Notice of Modification

Section 75W of the *Environmental Planning and Assessment Act 1979*

The project approval (MP 07_0103) granted by the Planning Assessment Commission, as delegate for the Minister for Planning and Infrastructure, for the NRE No. 1 Colliery Preliminary Works Project on 13 October 2011.

APPENDIX 2: PROJECT LAYOUT PLAN

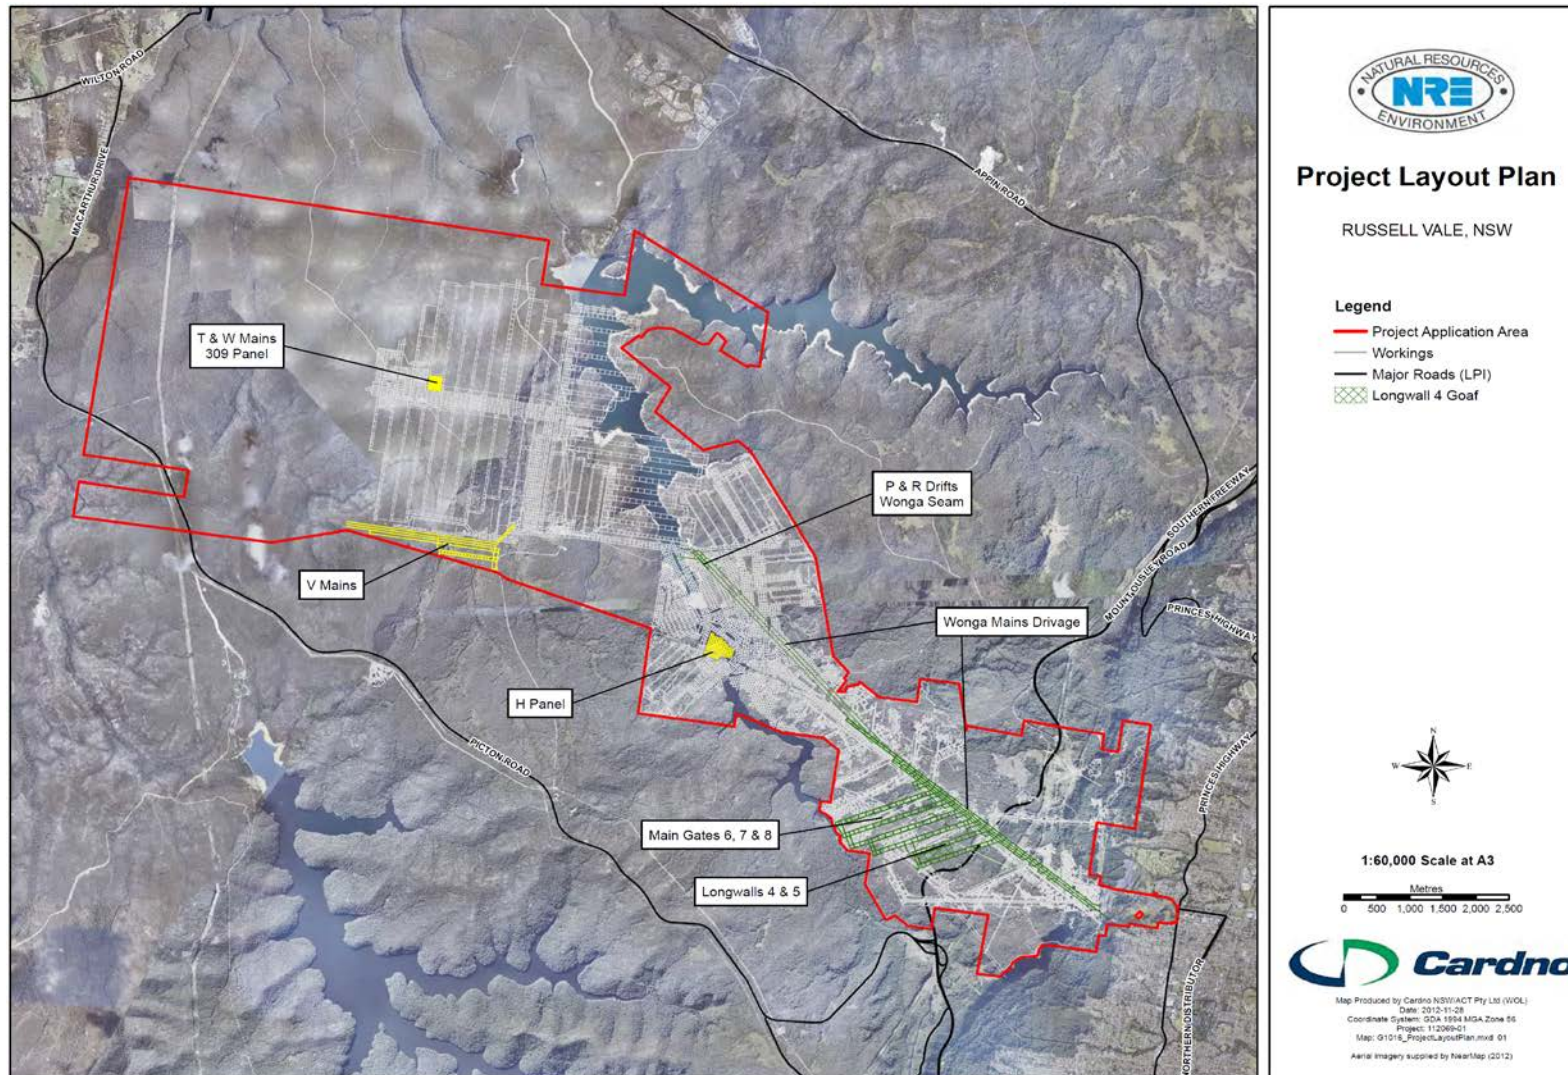
10. In Appendix 2: Project Layout Plan, delete the existing plan and replace with the following plan:
